**From:** Leif Langlois <leiflanglois@gmail.com>  
**Sent:** Tuesday, January 13, 2015 1:18 PM  
**To:** Kaycee Hathaway  
**Cc:** mjn@mjnealaia.com  
**Subject:** Fwd: SE-14-00011 Gorw Bros: Additional Information 1.12.2015  
**Attachments:** SE-14-00011 Grow Bros Additional Information Request 1.12.2015.pdf; SE-14-00011 Grow Bros Landscping Plan 11.21.2014.pdf

## KITTITAS COUNTY COMMUNITY DEVELOPMENT SERVICES

January 12, 2015

RE: Grow Bros SEPA, SE-14-00011

Exhibit A

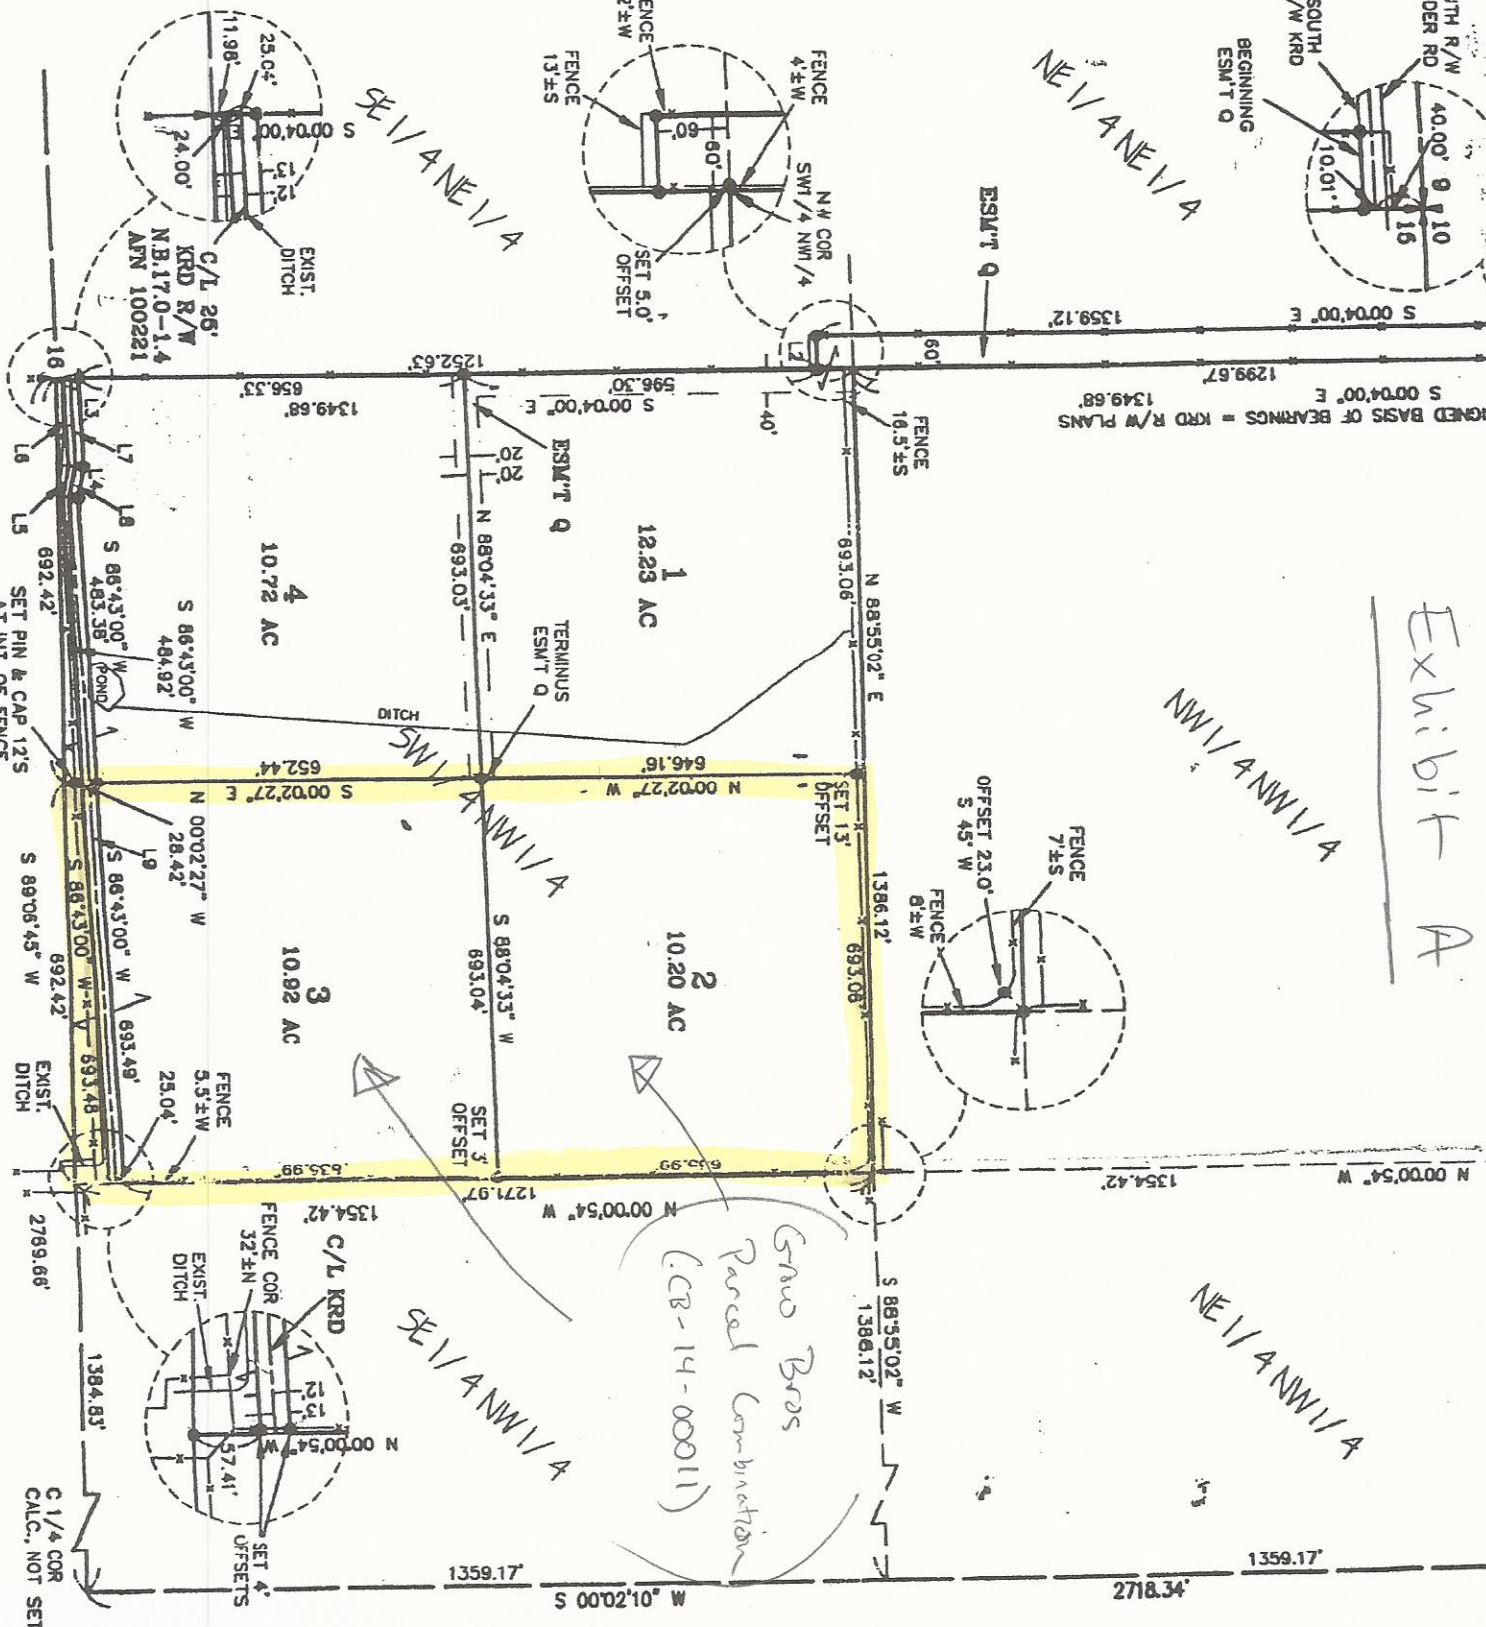
1. CDS is in receipt of the additional information submitted on January 7, 2015. After review of said additional information with regards to the original application there is a discrepancy. Within the SEPA checklist Question A. Background number 11. *21.12 acres, I-502 grow facility. (8) 30' x 80' greenhouses, with (2) 8' x 20' storage structures, (20) 10x 12' portable starter structures, an office and a 10 x 12' security building.* & the site plan submitted as requested by CDS shows double what is stated. CDS will need the applicant to either amend the site plan or Question A. Number 11 of the SEPA checklist for consistency.

# GrowBros Landscape Plan

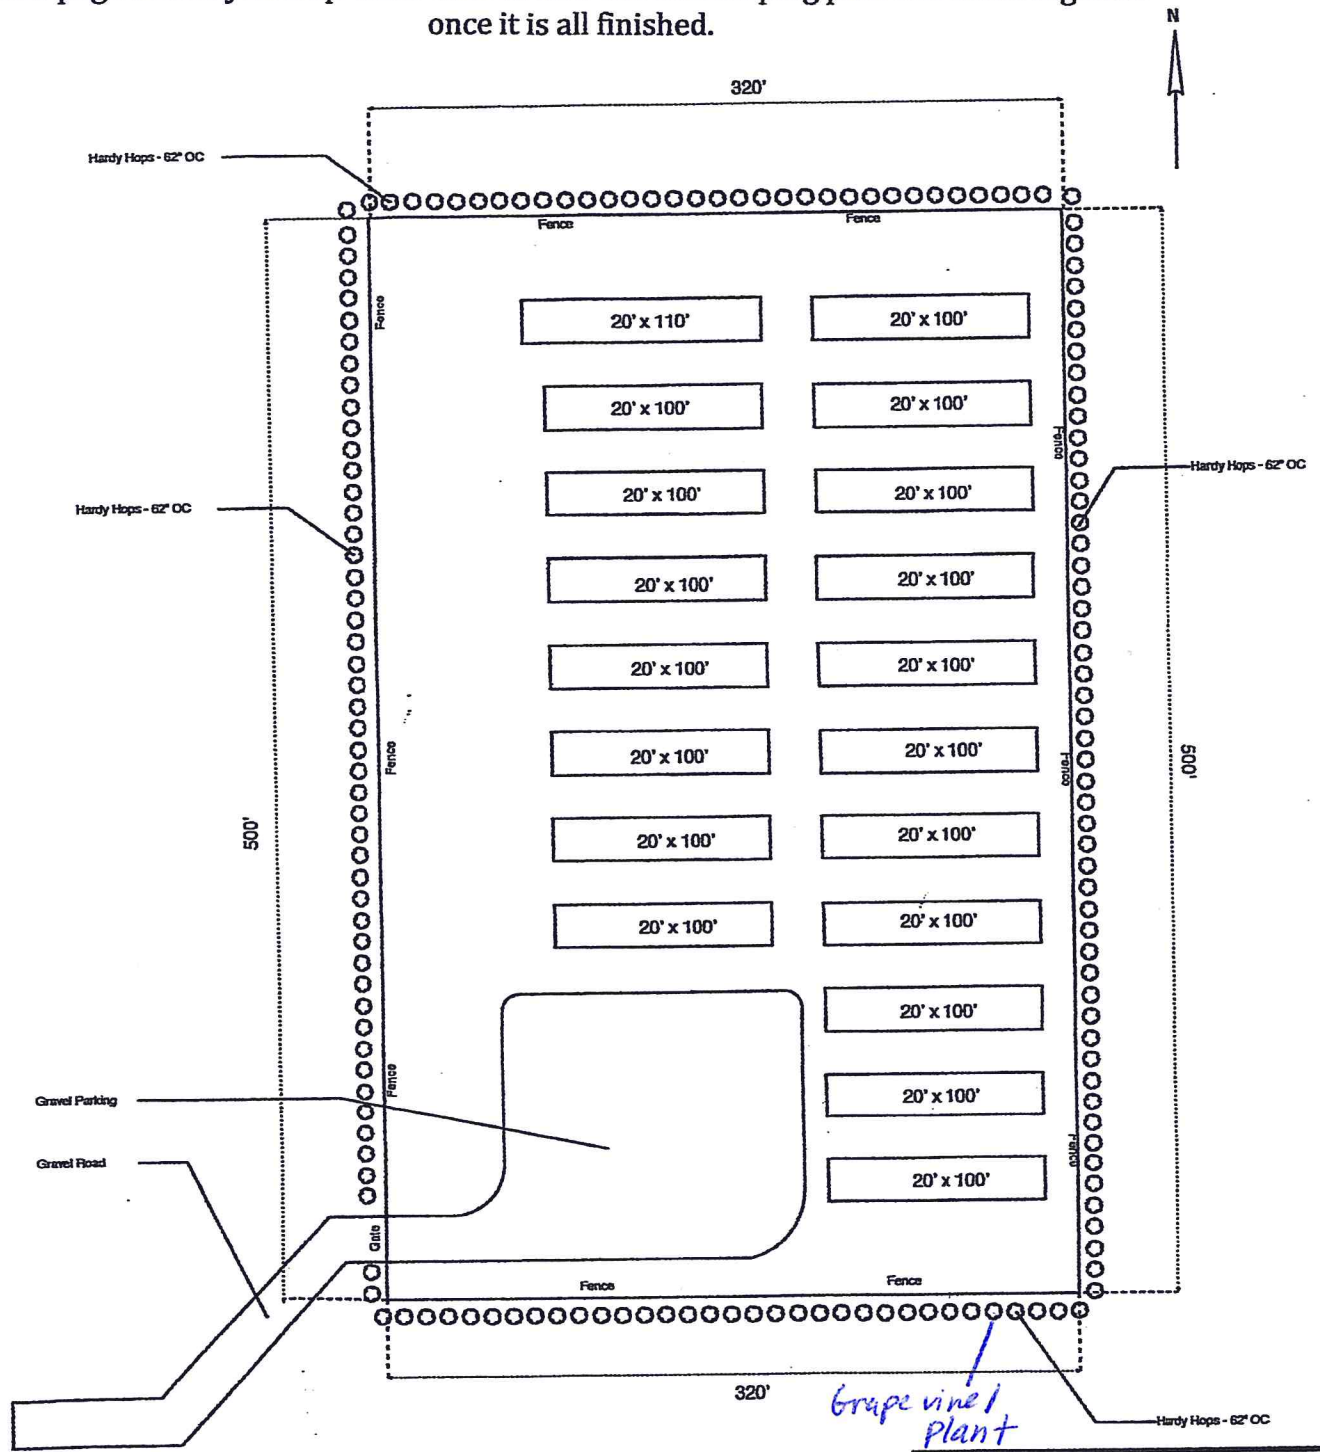
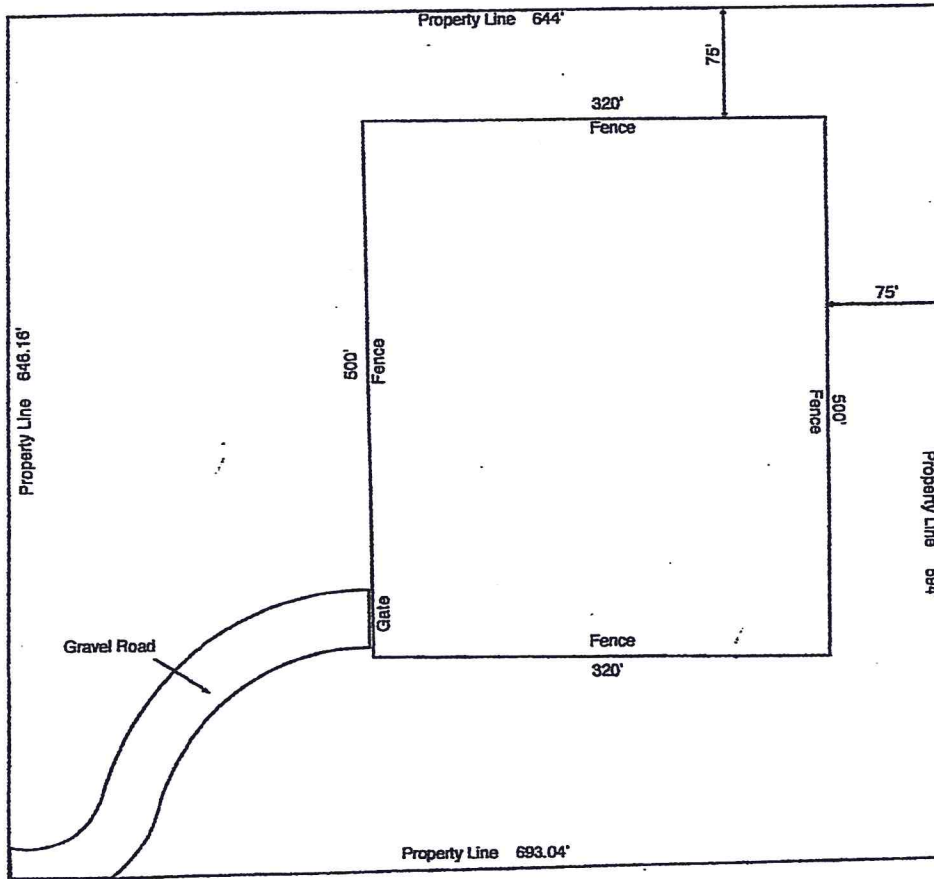
3. Clarification on question B. Environmental Health Section 4. Sub section d. Proposed landscaping, use of native plants, or other measures to preserve or enhance vegetation on the site, if any: *Hops planted at fence perimeter, 62 inches on center for sight obscuring.* In regards to this question is the landscaping plan turned in to CDS on November 21, 2014, see attached documents, for BP-14-00772, fence permit stating that there will be alternating hops and grape vines/plants totaling 166 plants, apply to this question?

In regards to your clarification question #3 in your letter dated January 12, 2015 pertaining to SEPA SE-14-00011 question B, Environment Health Section 4, Sub section d. please use the landscape plan turned into the CDS on November 21, 2014. In the mentioned plan BP-14-00772 please adopt the included fence permit plan stating that there will be alternating hops and grapes vices/plants totaling 166 plants and apply and use this for clarification of questions #3.
